**RESPONSE TO REQUEST FOR ADDITIONAL INFORMATION
SSD-11429726 – EDEN STREET COMMUNITIES PLUS**

This letter has been prepared by Ethos Urban on behalf of Arncliffe Eden Property Pty Ltd in response to the Request for Additional Information (RFI) issued by the Department of Planning and Environment (DPE) for SSD-11429726 dated 17 March 2022. SSD-11429726 seeks approval for the development of land at 26-42 Eden Street and 161-179 Princes Highway, Arncliffe (the site) into a mixed-use precinct with retail and residential uses, involving both market and social housing.

STANBURY
TRAFFIC
PLANNING
TRAFFIC, PARKING & TRANSPORT CONSULTANTS

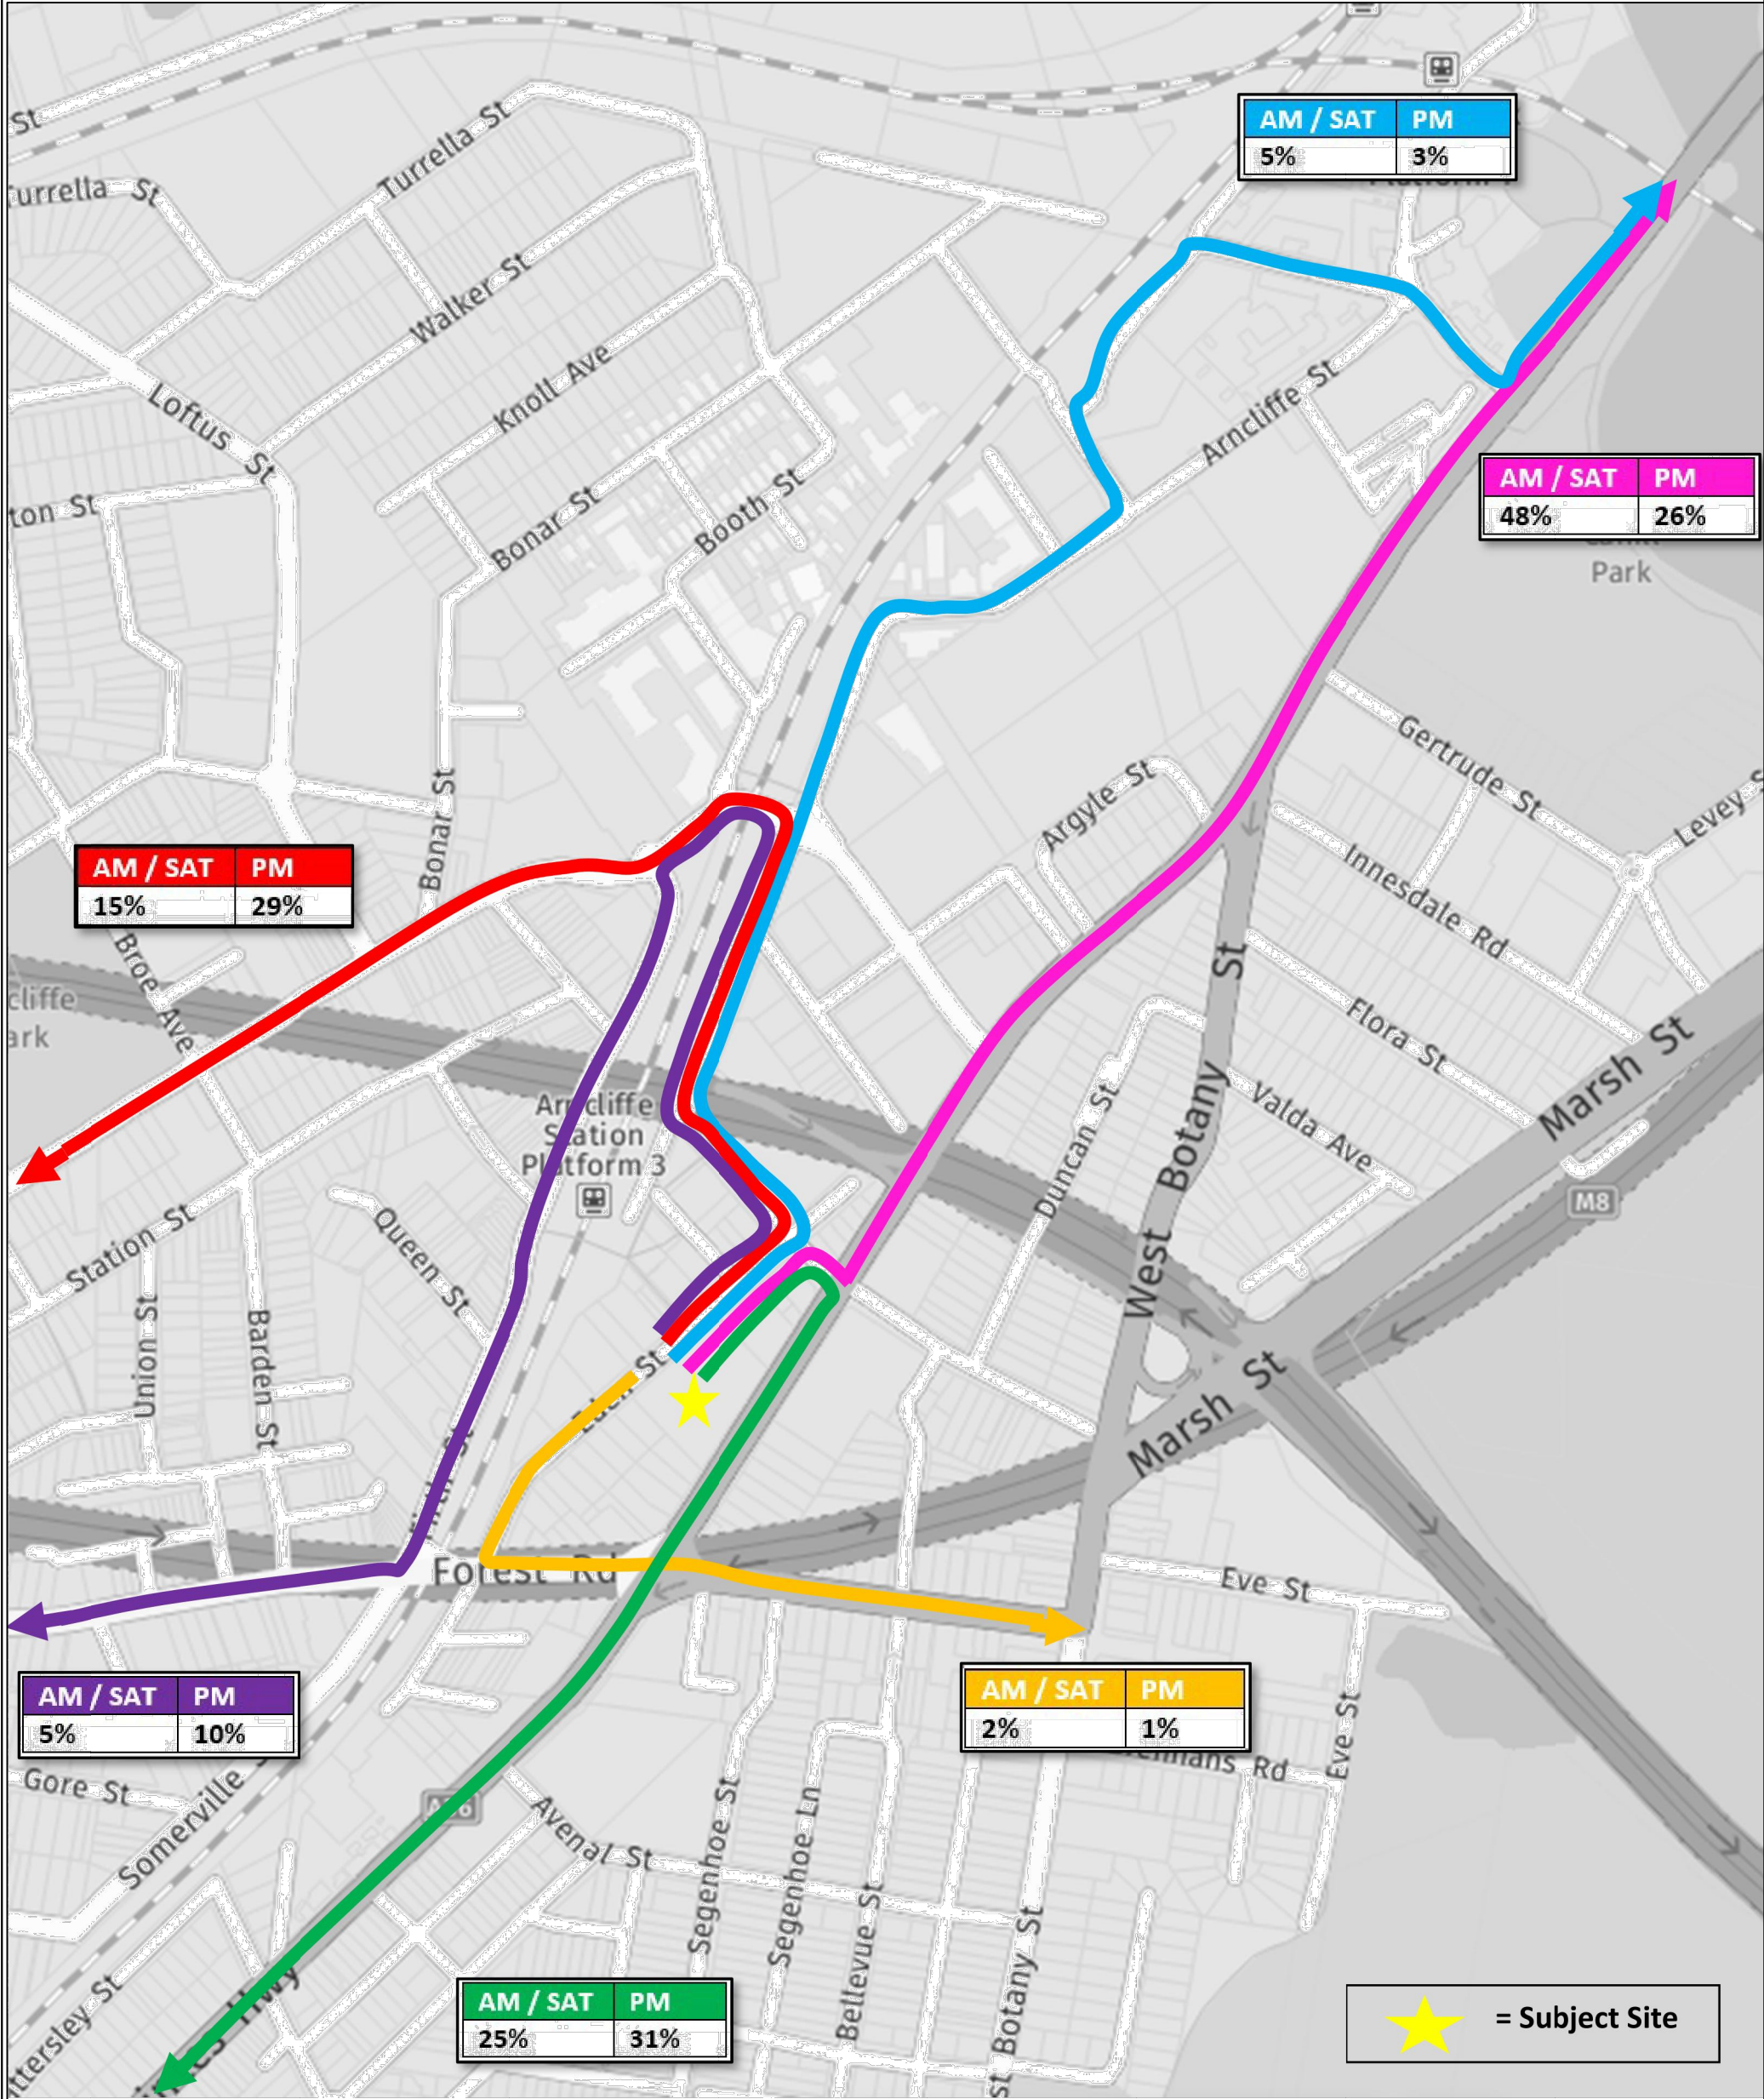
Transport		
15	Provide a summary clearly showing: <ul style="list-style-type: none"> existing and proposed trips and impacts to intersection performance (LOS) during peak periods a diagrammatic representation of predicted travel routes to and from the site. 	Refer to Intersection Performance and Travel Route diagrams prepared by Stanbury Traffic Consulting at Attachment D .
16	Provide details of the studies/analysis undertaken to discount the possibility of including a basement easement to the site to the south.	<p>Potential Basement Easement Connection Statements have been prepared by TTW, Stanbury Traffic Consulting and Corporate Counsel Services at Appendices E, F and G, confirming that a potential future basement connection to the lots south of the site would be unfeasible from structural integrity, traffic planning, and legal perspectives.</p> <p>Accordingly, the proposal would be unable to accommodate this easement.</p>

**Figure 8 Wind Mitigation Recommendations**

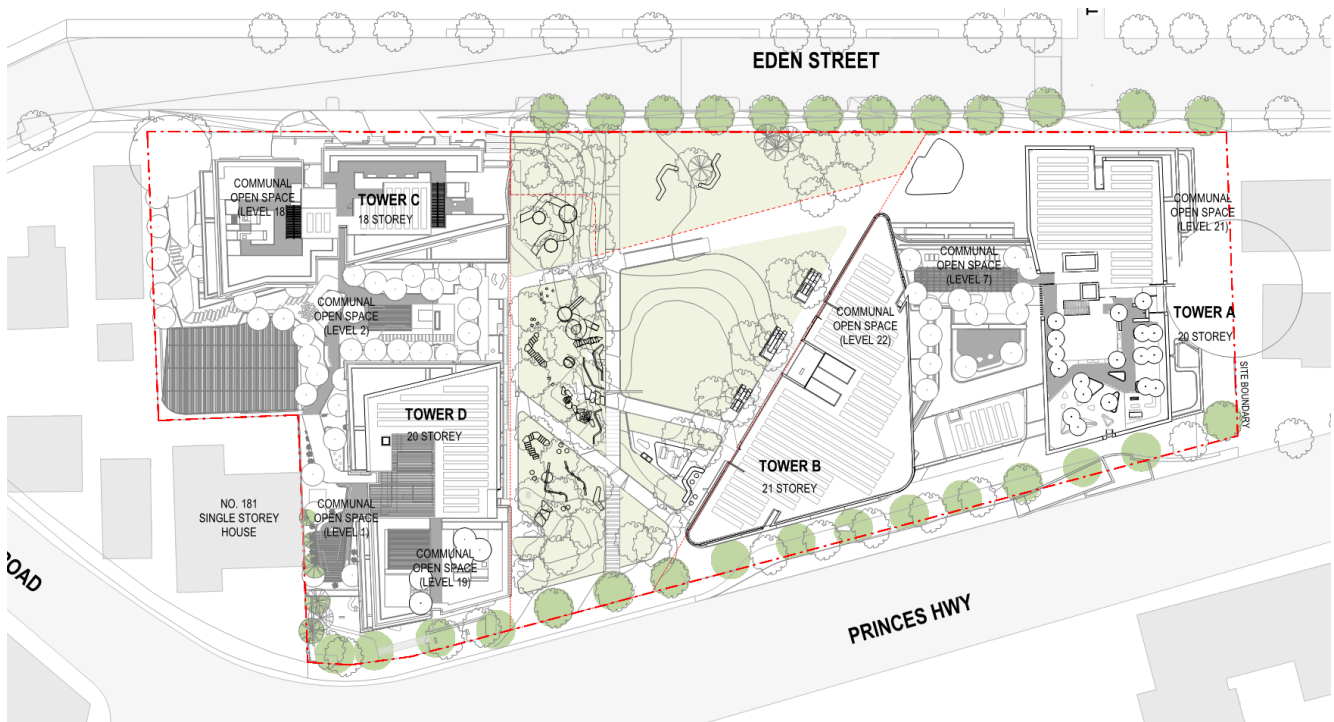
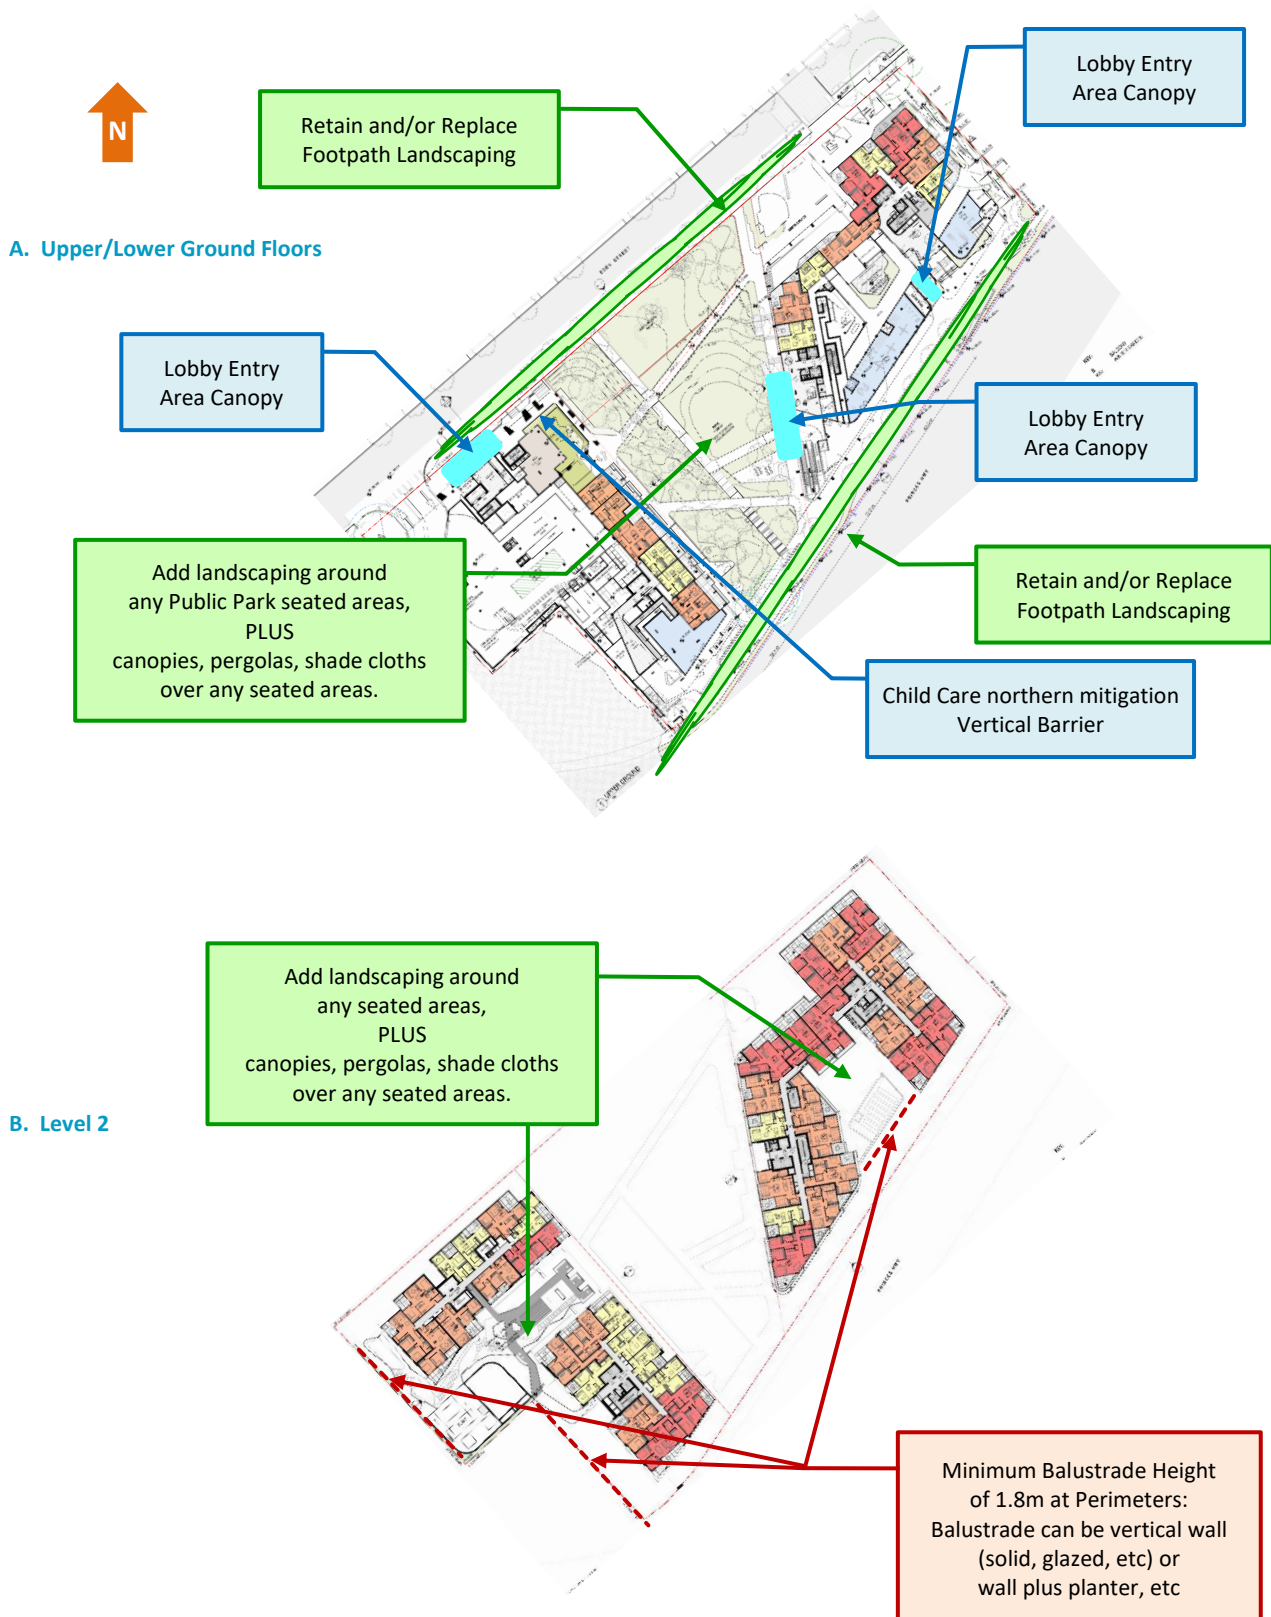
24	Update the wind impact assessment to reflect the RtS scheme.	An Updated Wind Impact Assessment has been prepared by SLR at Attachment L to reflect the scheme as refined under the RTS.
